File: SF16/2245  
Job ID No: DOC16/251425  
Your Ref: SSD7317

**RE: Response to Submissions for the Redevelopment of Australian Technology Park,  
Locomotive Street, Eveleigh (SSD 7317)**

**Pauline McKenzie**  
Acting Executive Director, Heritage Division  
Office of Environment & Heritage  
**As Delegate of the NSW Heritage Council**  
DATE 3 June 2016

B2 Locomotive Street public domain.

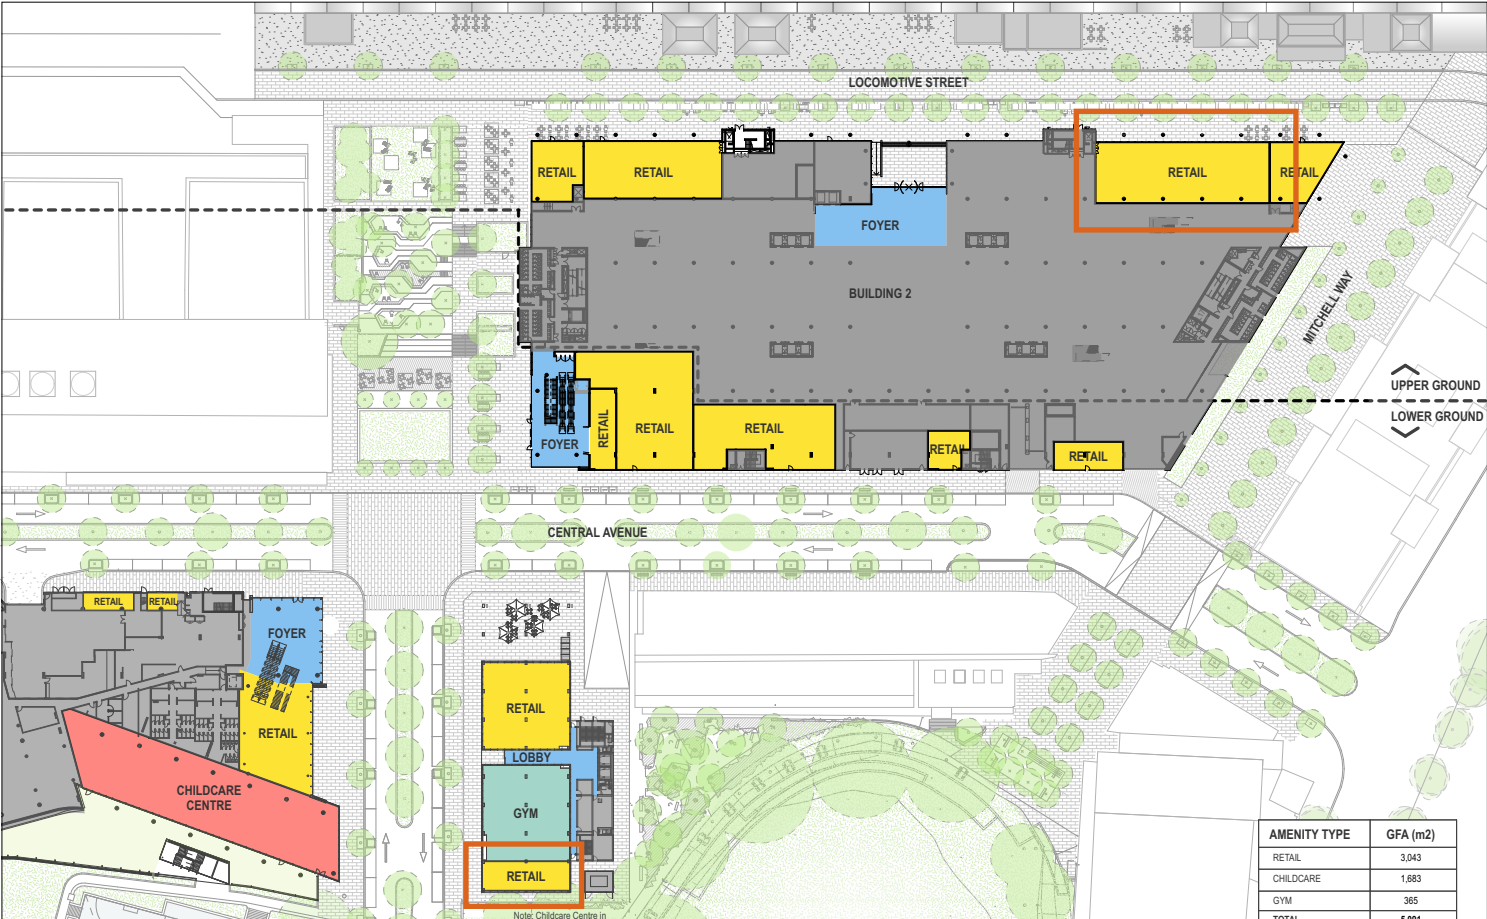
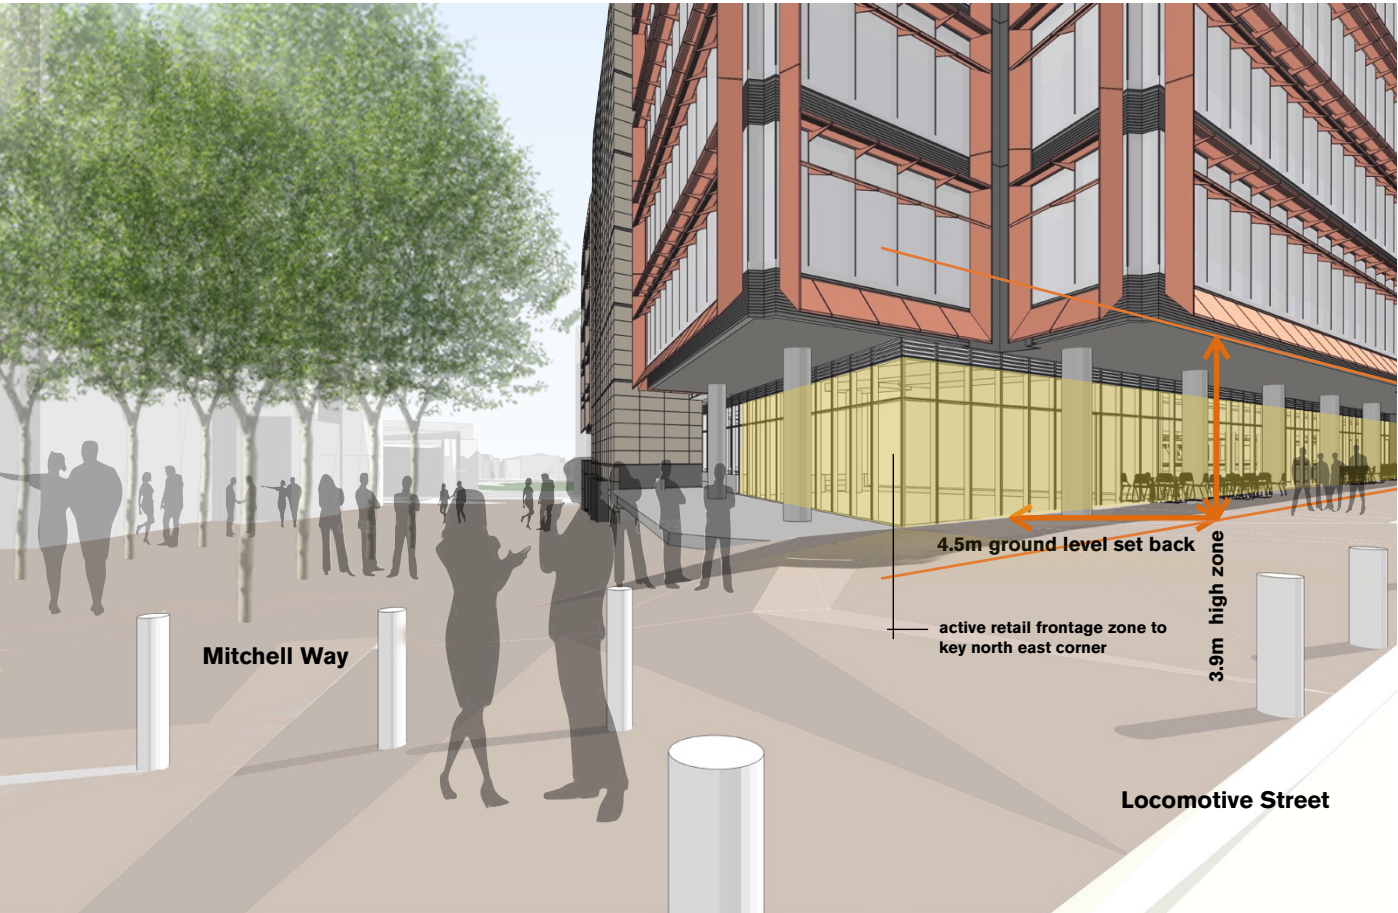
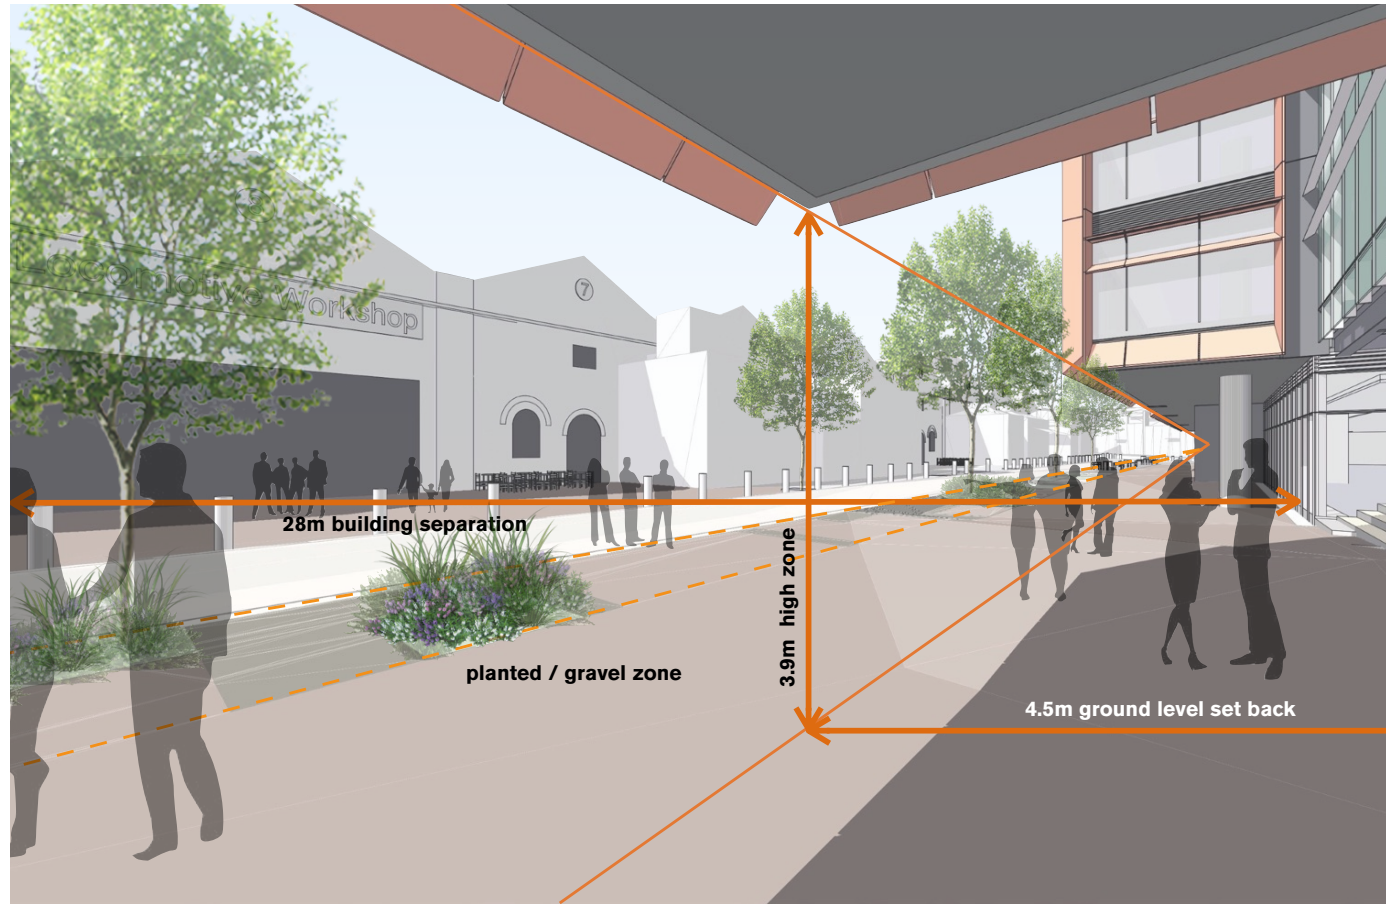
The Heritage Council's submission dated 7 March 2016 raised concerns that the northern alignment and articulation of Building 2 along Locomotive Street will diminish the scale and setting of the former Locomotive Workshops, and notes that the alignment of Building 2 does not comply with setback requirements of the Redfern Waterloo Built Environment Plan (BEP) 2006. The submission also states that the proposed two rows of trees along Locomotive Street may adversely alter the industrial character and setting of the Locomotive Workshops, and recommends that these aspects of the proposal be modified to reduce heritage impacts.

The Response to Submissions report states that the proposed alignment of Building 2 complies with the statutory planning controls under the State Significant Precincts SEPP, and that the BEP 2006 has "limited/no formal statutory planning weight". It provides further detail regarding the design of Building 2 and landscaping along Locomotive Street but does not propose any changes to these aspects of the proposal.

The response is not considered to have mitigated the concerns raised by the Heritage Council. The Heritage Council, therefore, maintains its previous assessment of SSD 7317 and recommends that the comments and recommended conditions of consent in the Heritage Council submission dated 7 March 2016 be considered during determination.
